From: Plant, Tom - Communities <Tom.Plant@Oxfordshire.gov.uk>
Sent: 23 April 2021 18:54
To: Wayne Campbell
Cc: Transport CDC Minor; Planning; Councillor Kieron Mallon
Subject: 21/00588/ADV - Land Including OS7400 5257 4976 2661 And 5257 South Of Salt Way Adj To Bloxham Road Banbury

Planning application: 21/00588/ADV
Location: Land Including OS7400 5257 4976 2661 And 5257 South Of Salt Way Adj To Bloxham Road Banbury
Description: 2no advertising billboards and house builder flag poles
Type: Advertisement
Case Officer: Wayne Campbell

Oxfordshire County Council, as the Local Highways Authority, hereby notify the District Planning Authority that they **object** to the granting of advertisement permission.

# SITE PLAN

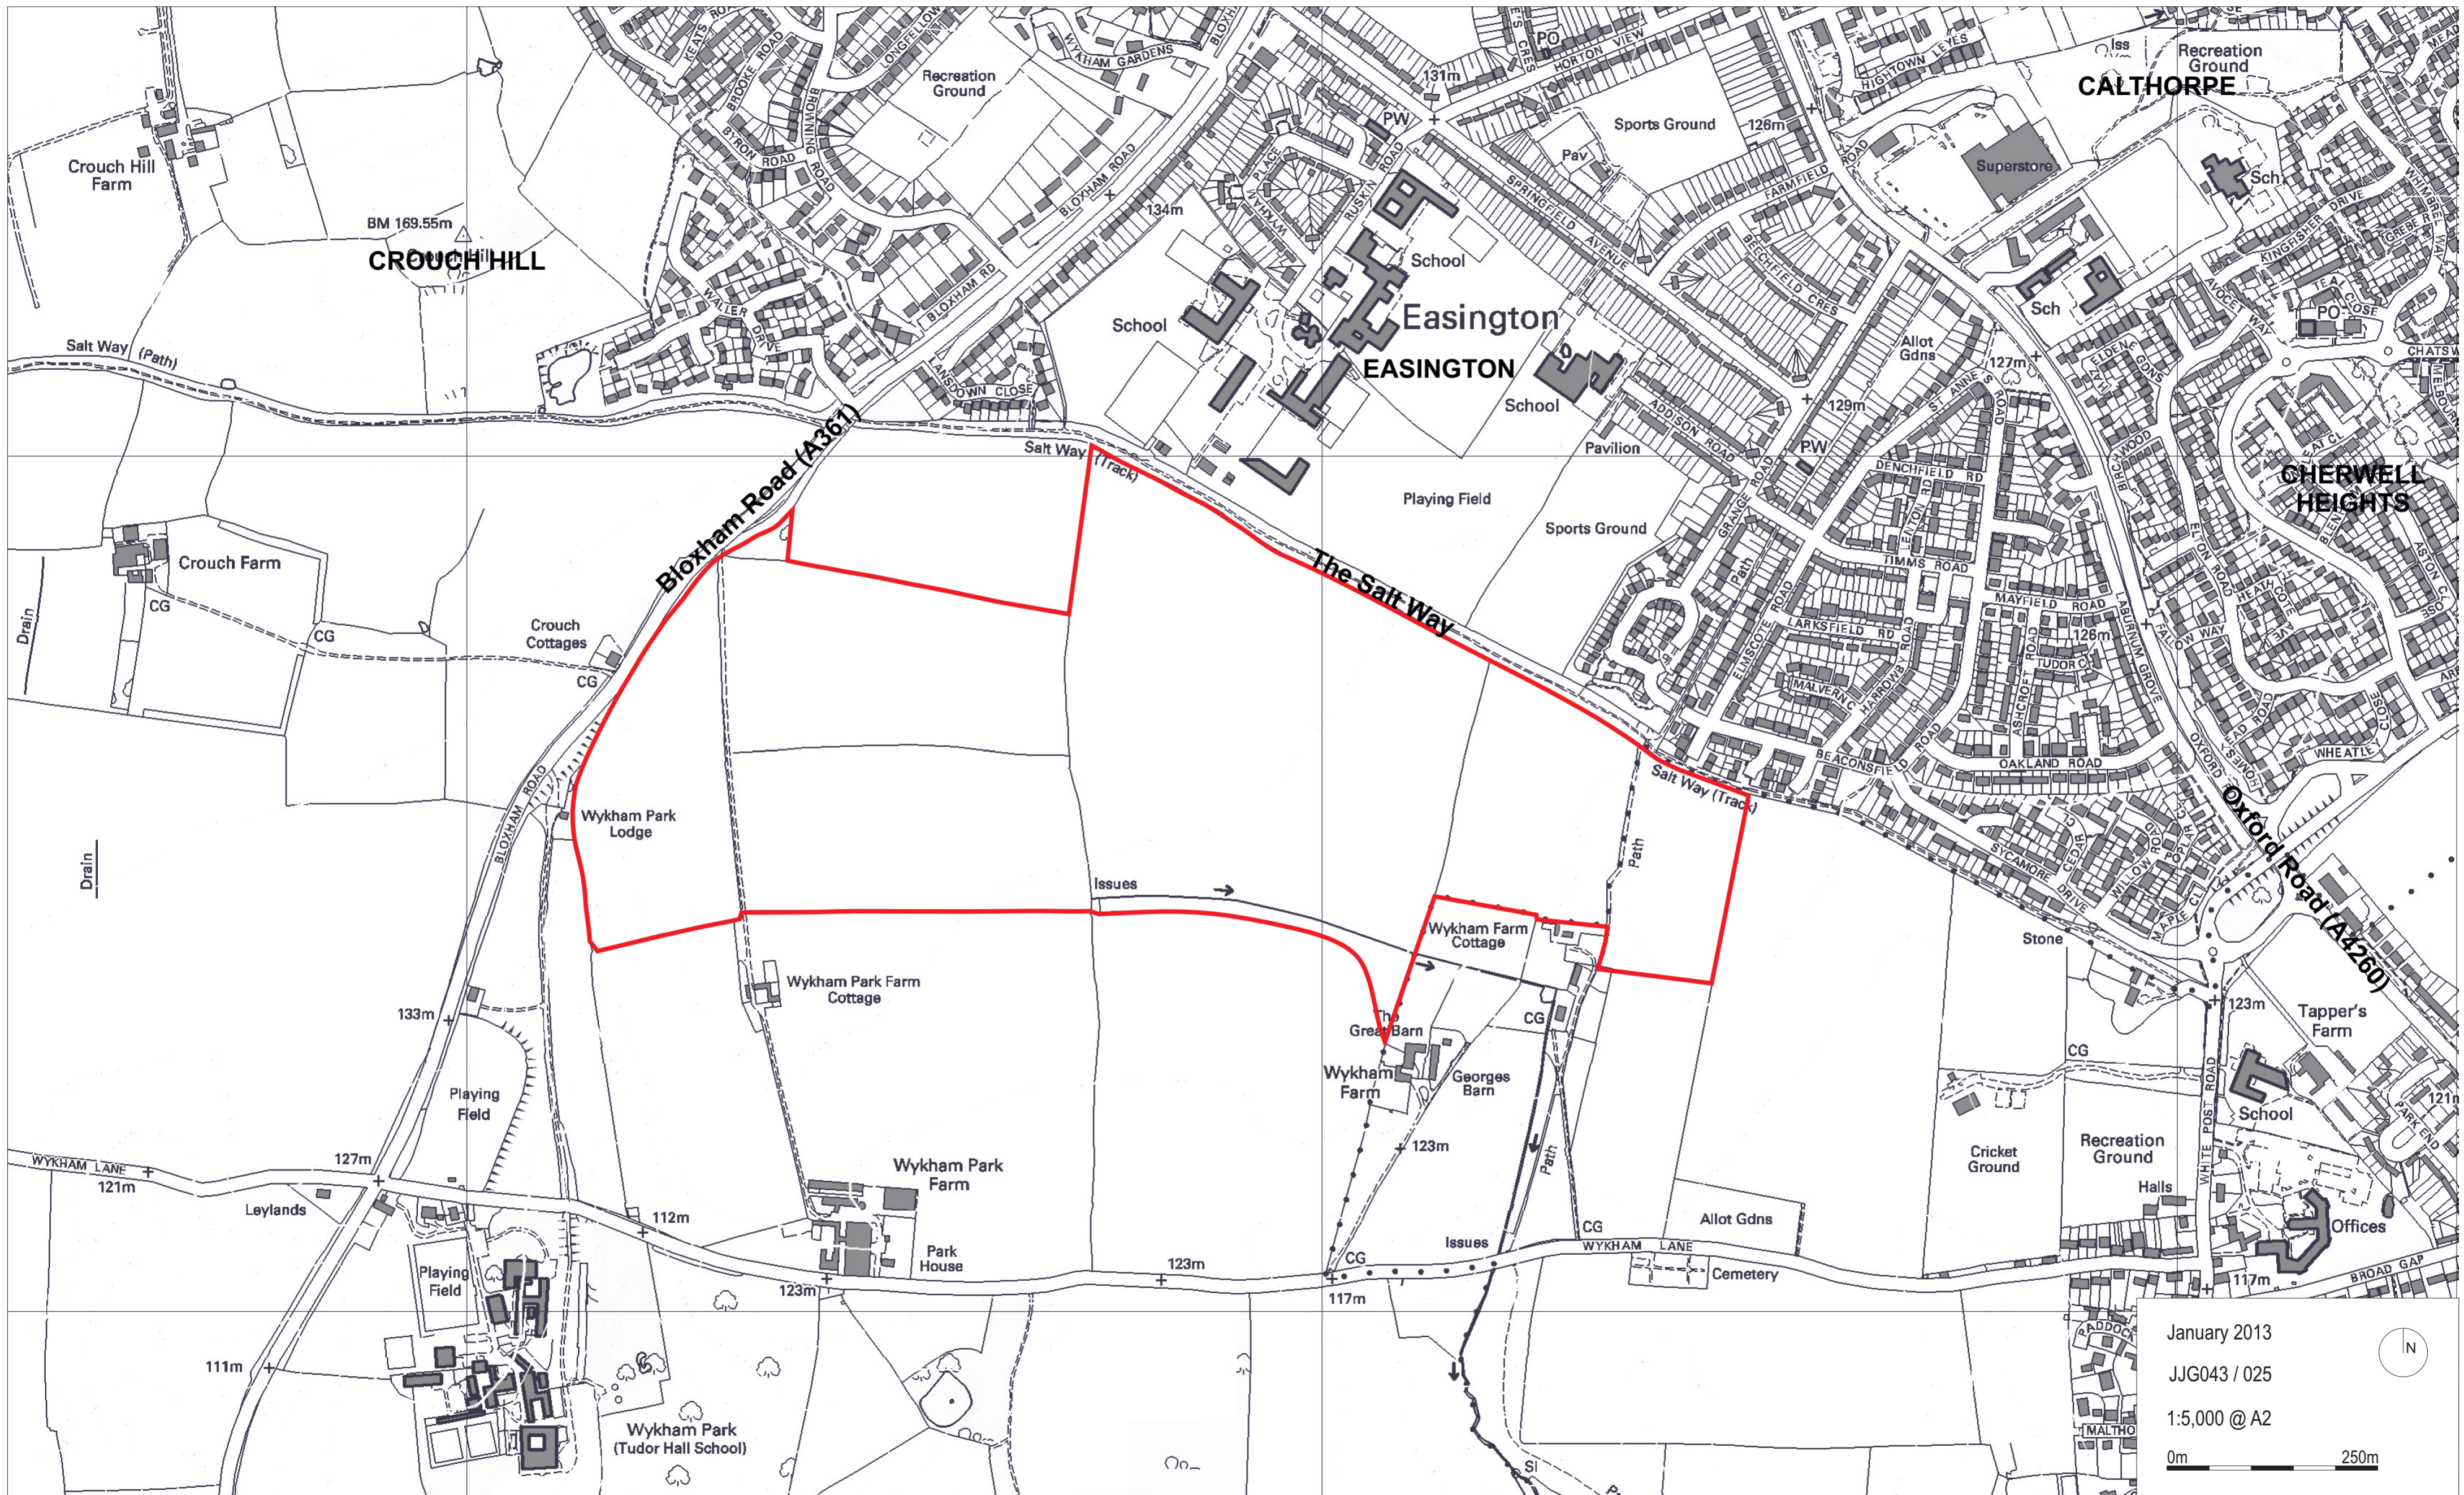
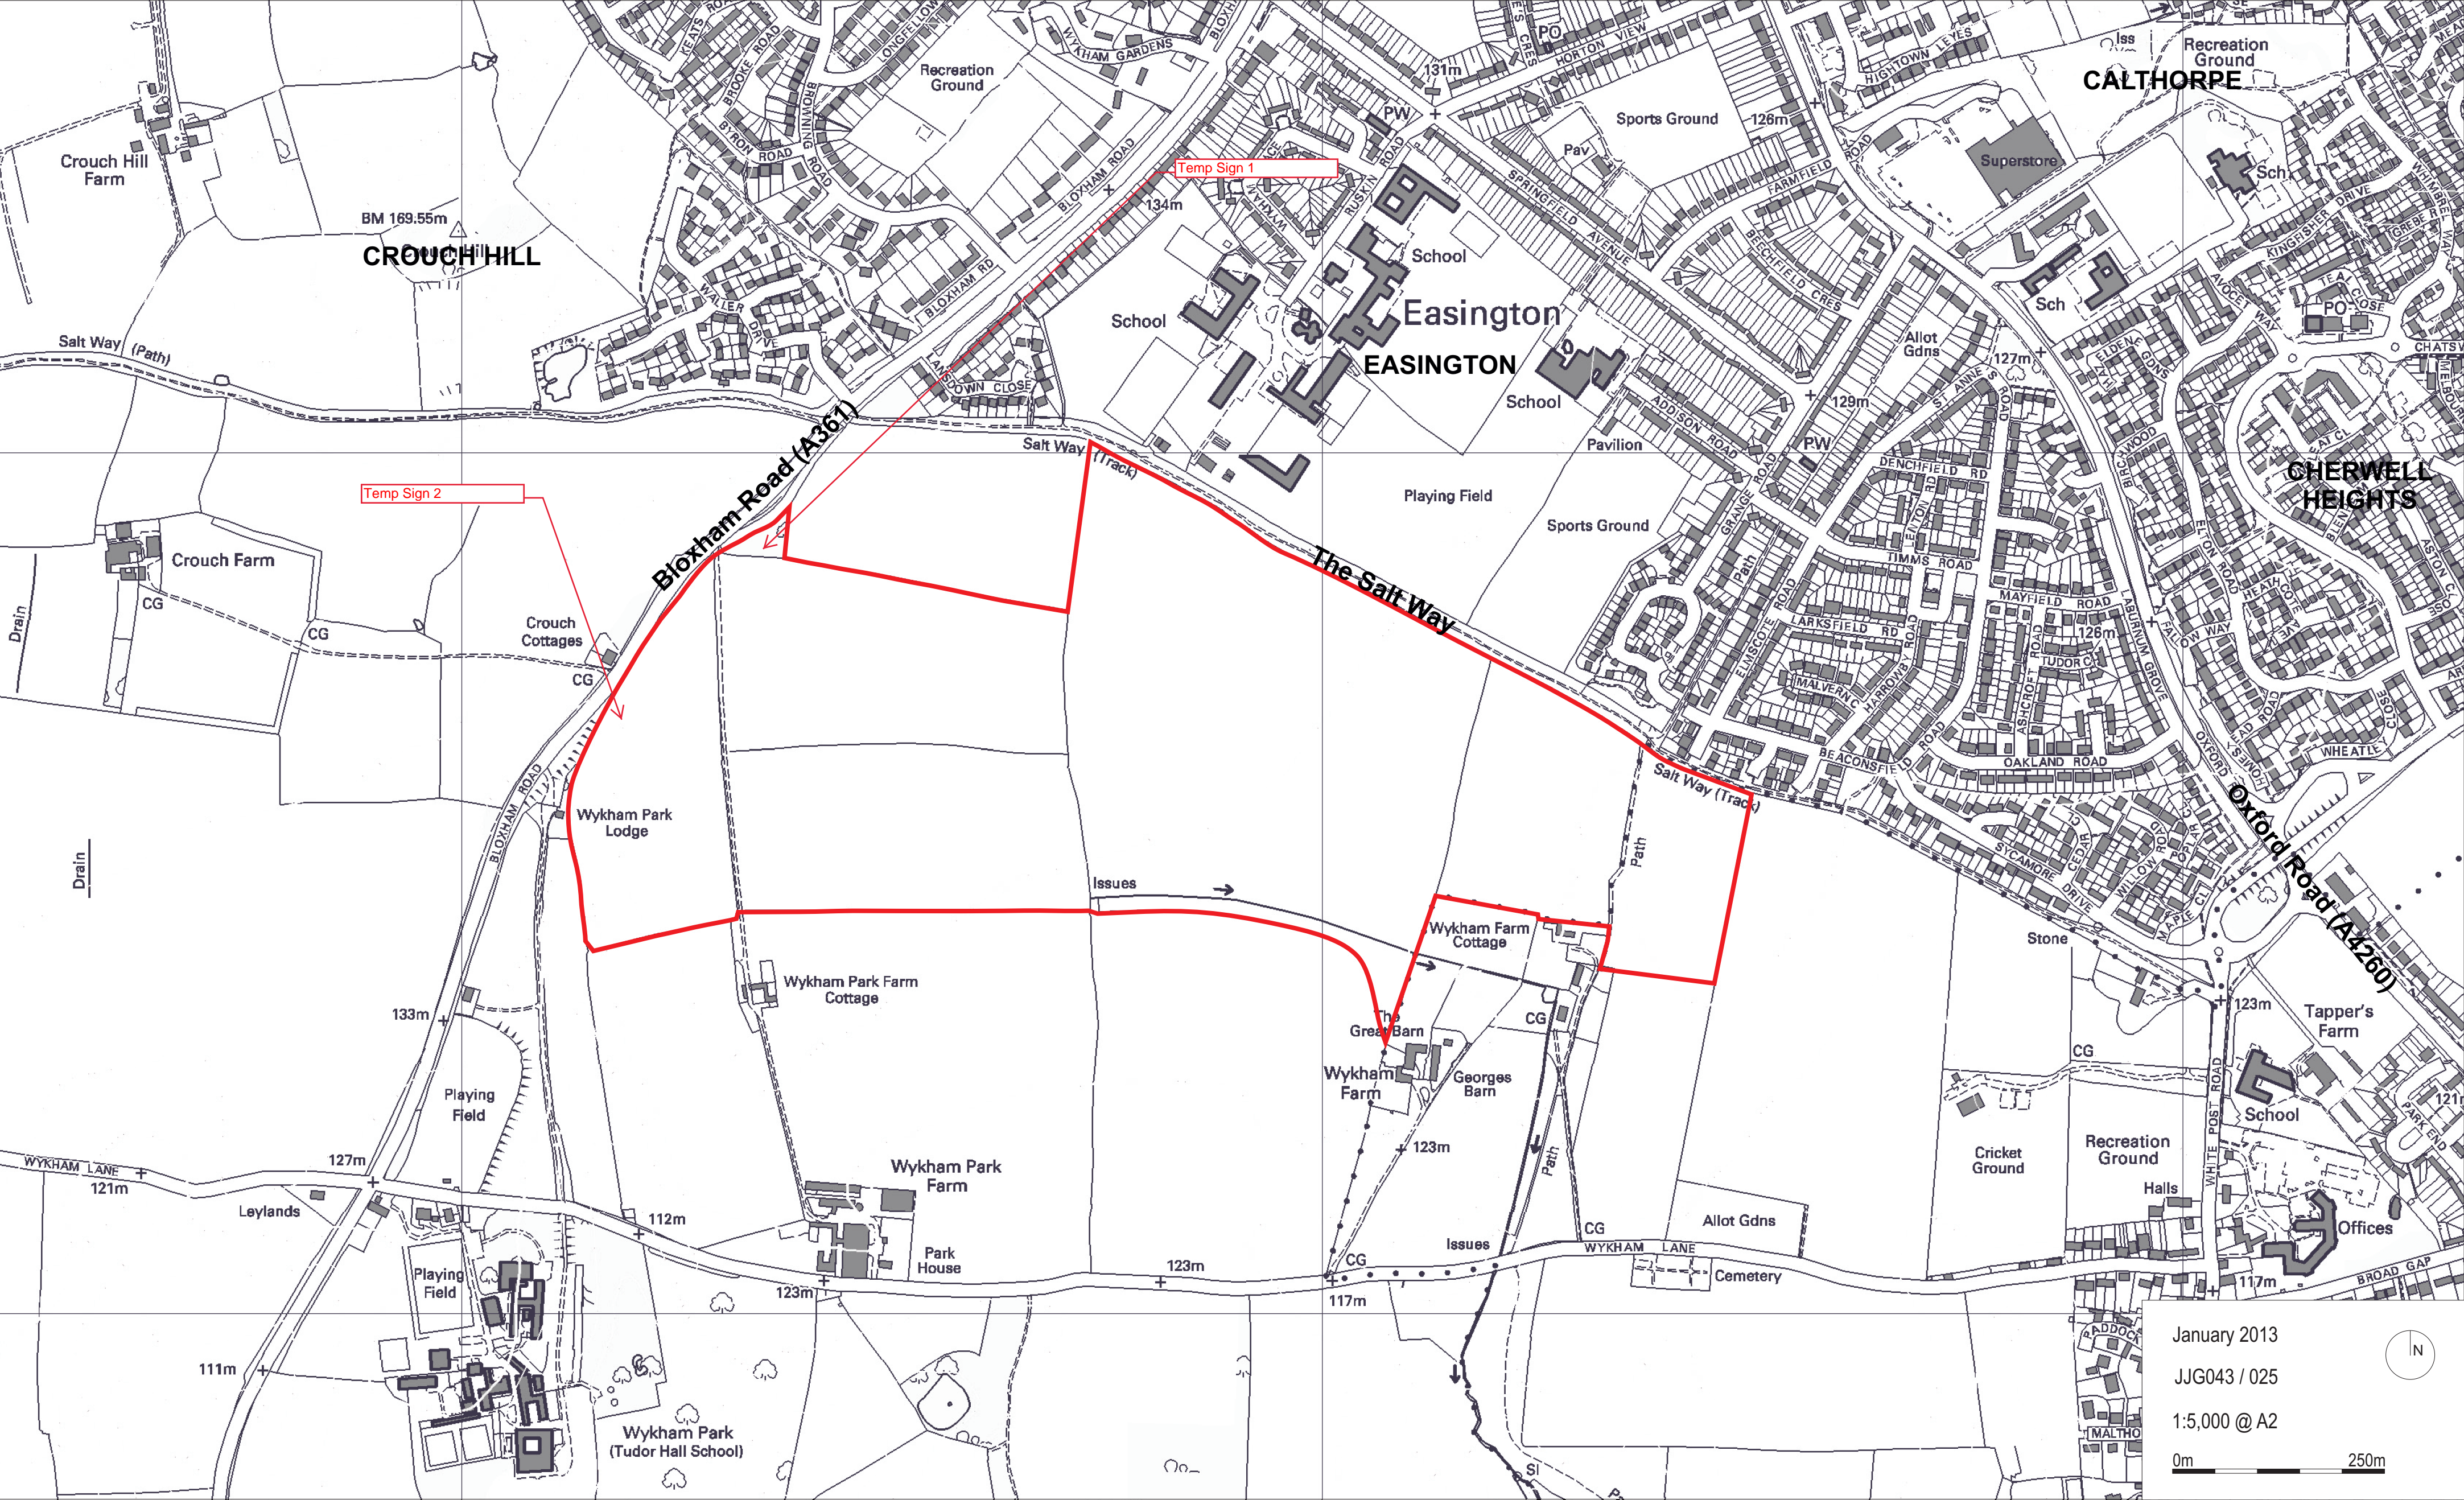
It is unclear from the submitted drawings as to where the proposed 14 flag pole signs (two each) and two billboard signs will be located in relation to the adopted public highway verge, this in addition to there being no reference on any of the submitted drawings as to where the 14 flag pole signs will be located. Further, the submitted site plan, drawing JJG043 appears out of date (January 2013) as it does not appear to show the recently installed roundabout for Parsons Piece, Tyrell and Bloxham Roads.

Finally, it is unclear from the submitted 2013 plans as to the location of the planned second roundabout to facilitate access to this development from the Bloxham Road, nor do the plans show the location of the planned spine road that will connect onto the recently installed highway works on White Post Road, Bodicote.

It would therefore be inappropriate for the LHA to comment on this application, other than to issue this holding **objection**, until such a time as the applicant can demonstrate that the proposed signs will not impact the highway, or the planned highway works here.
